The Member-Secretary
Chennai Metropolitan Develop-
ment Authority
1, Gandhi Irwin Road
Egmore, Chennai 600 008

82/9276/01

Sub: CMDA - Planning Permission - Construction of ~~Structure~~ ~~Apartment~~ ~~Flat~~

2nd floor of Residential/Commercial Building with a.d.v. at over no: 56/4
2nd floor Pillayar Koil Street, T.No: 4 Block: 24,
of Salyemman Village

**TERRACE FLOOR PLAN**

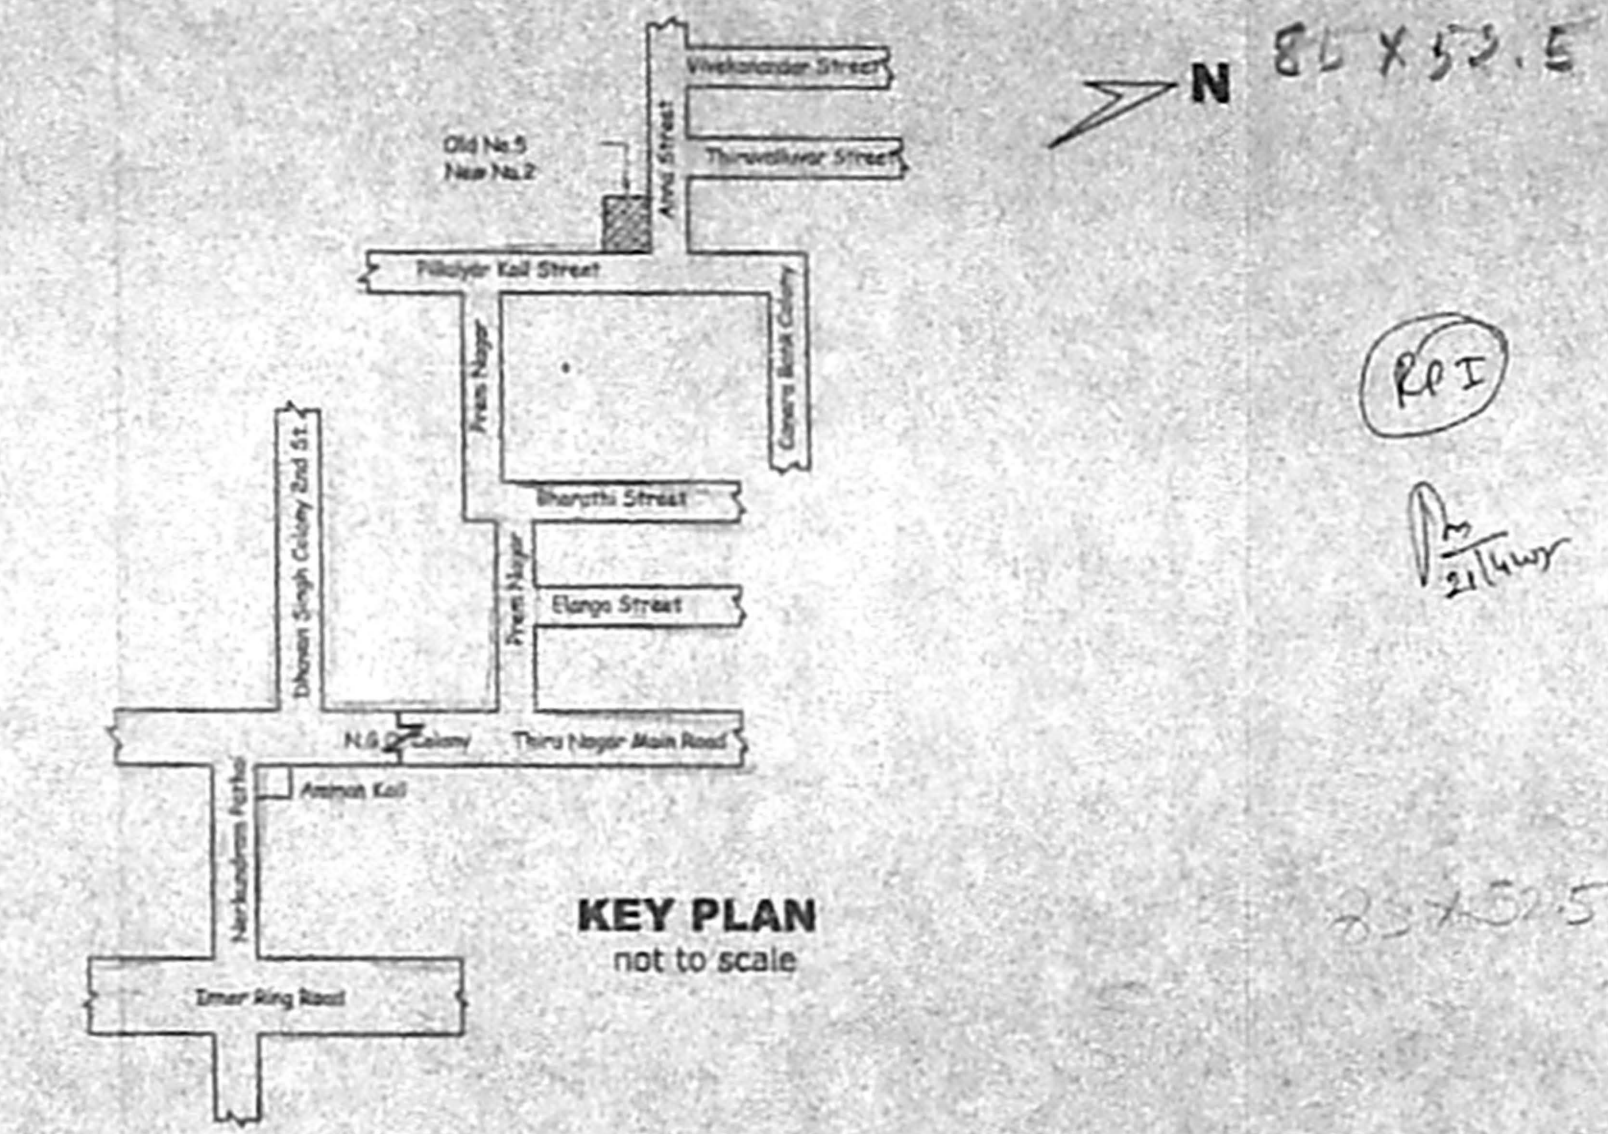
- (b) 5 Curves of RT. to be done,
- (i) plan measurements/ area has fully written down plan and has done. to be indicated in plan
- (ii) open sub-hole open terrace plan to be indicated in terrace plan plan.
